From: Sue Howell
Sent: 28 May 2015 13:58
To: Planning.Responses
Cc: Simon Davis
Subject: RE: Planning Consultation on: BE/60/15/PL

Comments from Greenspace:

NOTIFICATION FROM ARUN DISTRICT COUNCIL
Town & Country Planning Act 1990 (as amended)
Town and Country Planning (Development Management Procedure)
(England) Order 2010 (as amended)
Planning Permission
APPLICATION **BE/60/15/PL**
NO:

Description of Demolition of existing dwelling & erection of 8 No.
Works: three bedroom dwellings with new access & car
 parking.

PROPOSED SITE PLAN
(1:200)

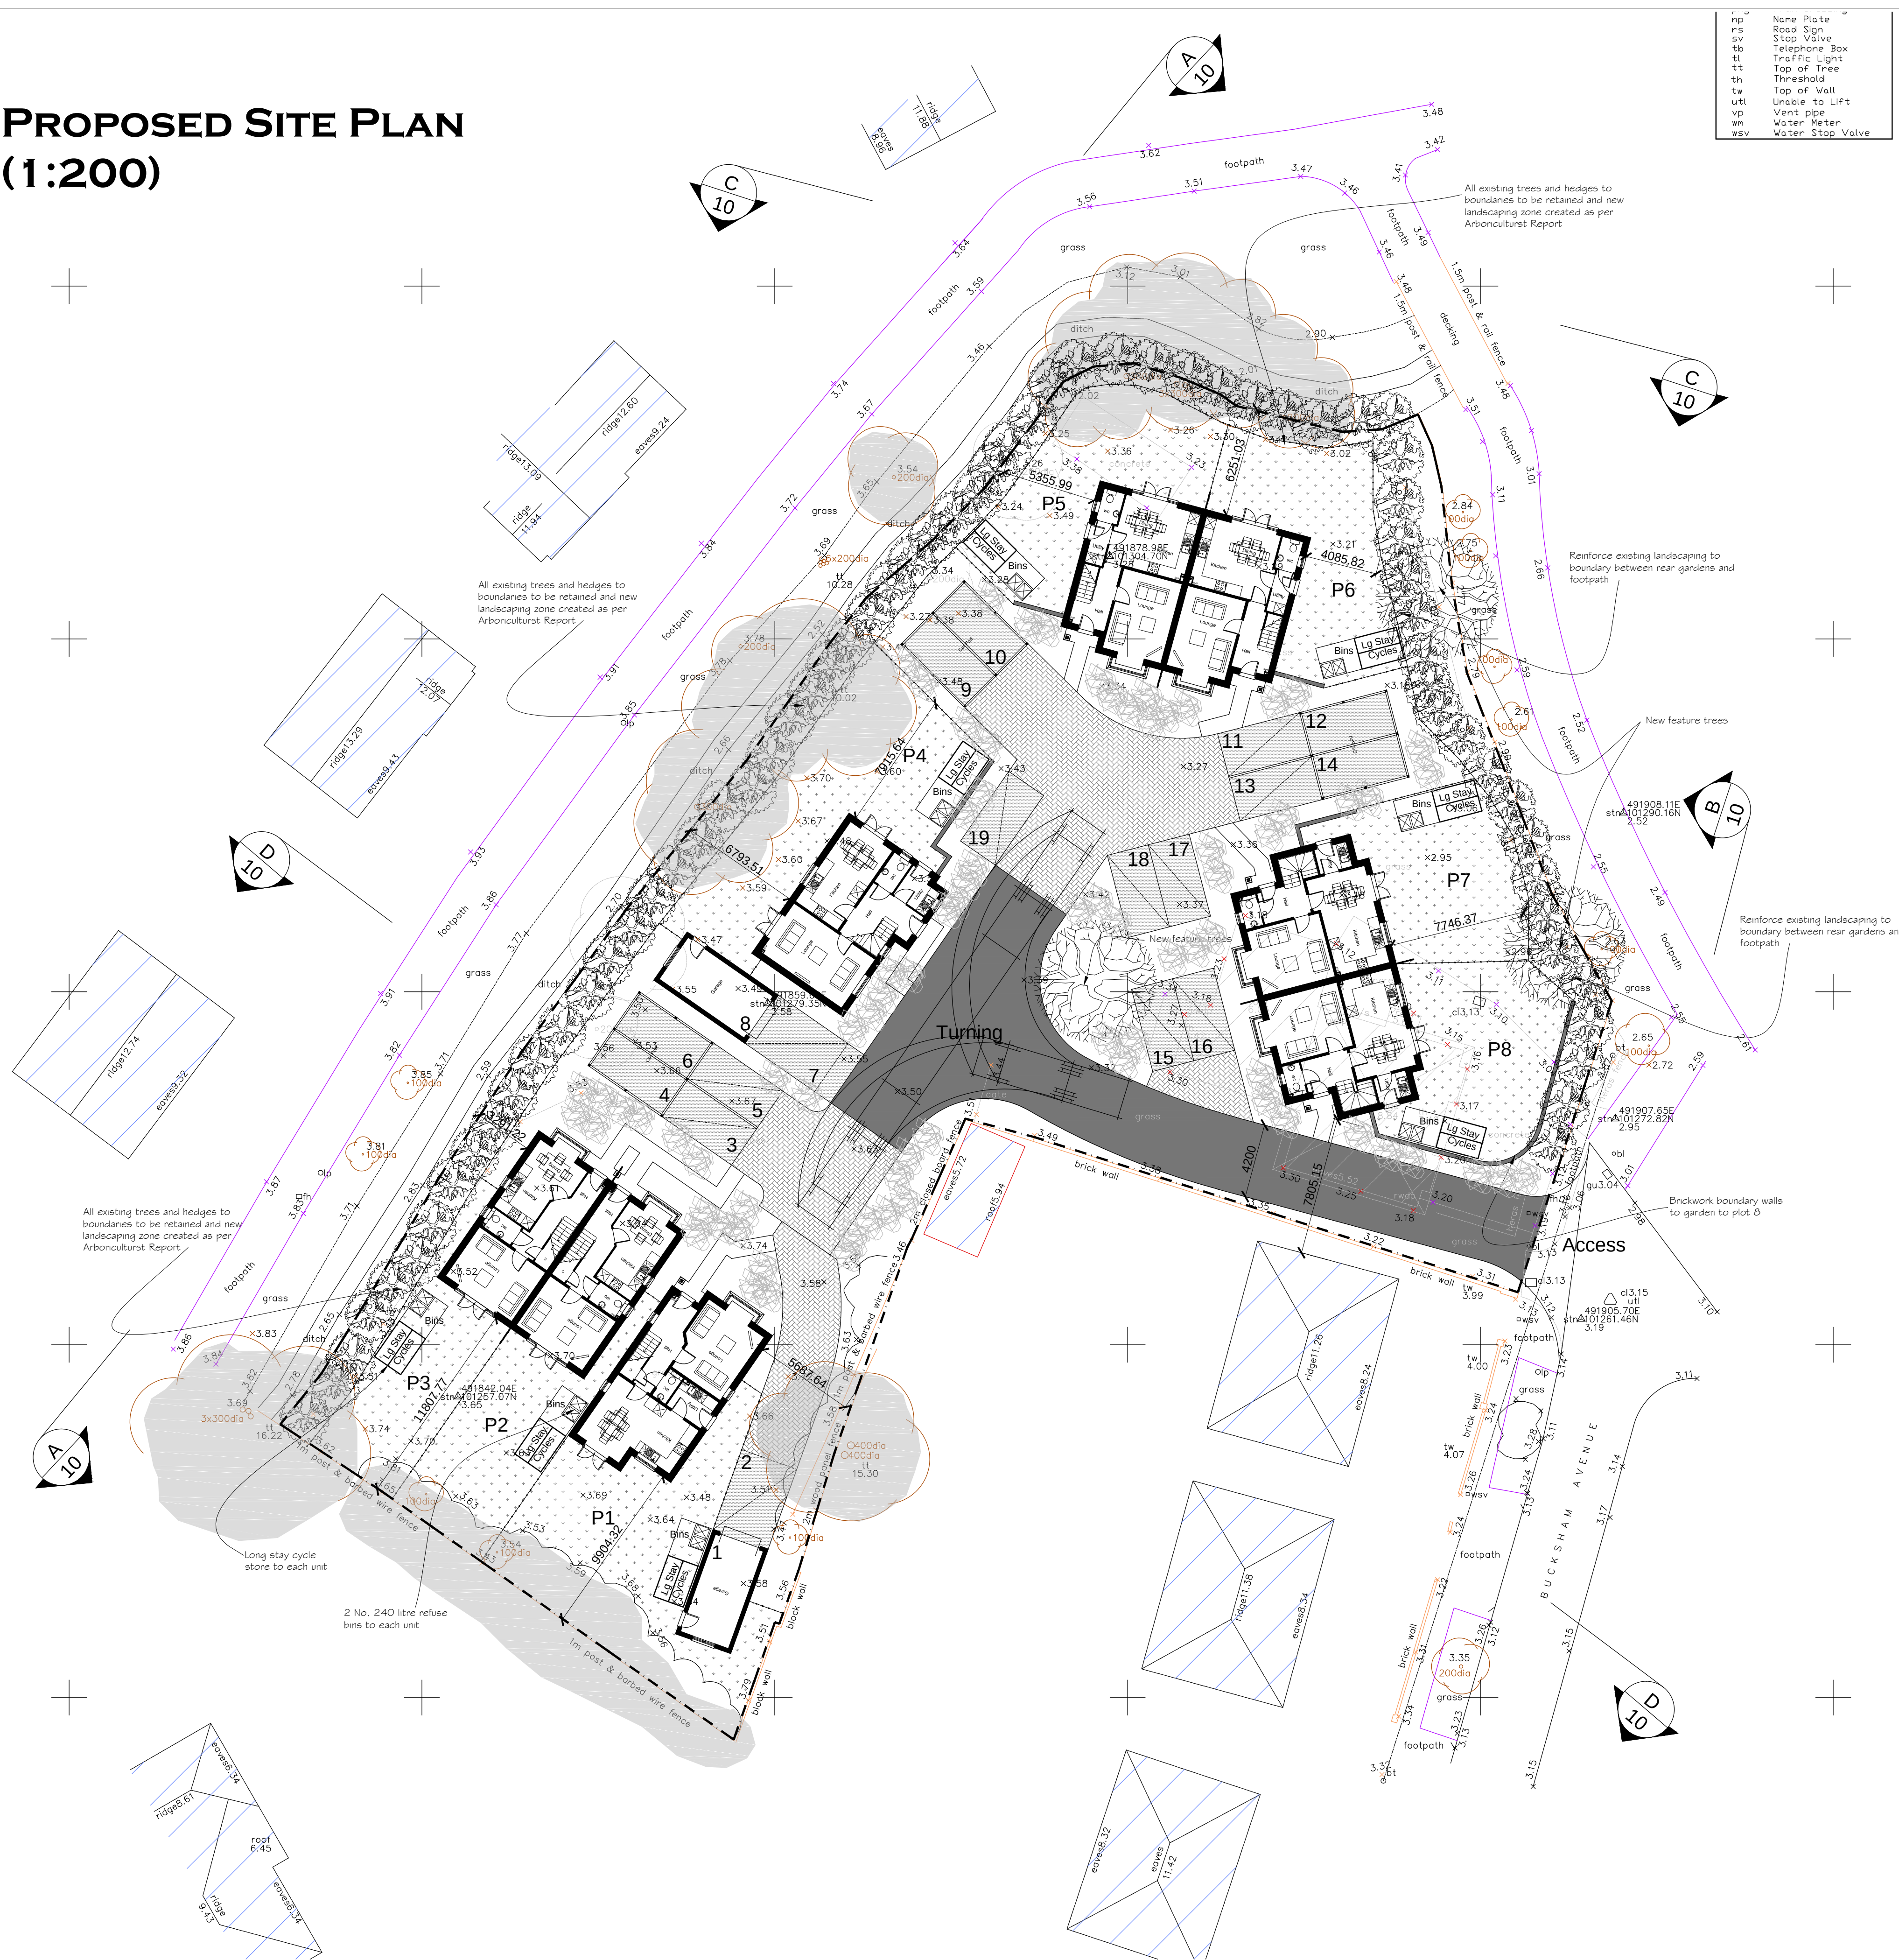
Landscape – Any trees or vegetation that fall within the proposed or periphery of the development, may provide significant aesthetic impact and screening to this location. Any trees in particular along the boundaries, and which provide screening of the adjacent properties could provide potential valuable screening and should be protected and retained. Any considered tree works within the site should be agreed with Arun District Councils Tree Officer. Root protection Areas (RPA) from the tree cover to the West / South-West of the site should extend into the development area. Before construction, a tree protection scheme must be in place for these/any retained trees adjacent trees whose root protection areas fall within the construction zone from neighbouring land. This would be required for both construction and heavy vehicle movements for deliveries. This should be in accordance with BS 5837:2012 'Trees in relation to construction'

A full landscape scheme should be submitted for approval, detailing species choice, position, densities and size at time of planting. This should be plotted in plan and list form and in relation to the trees and vegetation to be retained so that a clear picture of the proposals can be seen. These details are required to ensure that appropriate screening is provided, maintaining and uncompromising the setting and ensuring that the proposals fit within the area of neighbouring development and properties.
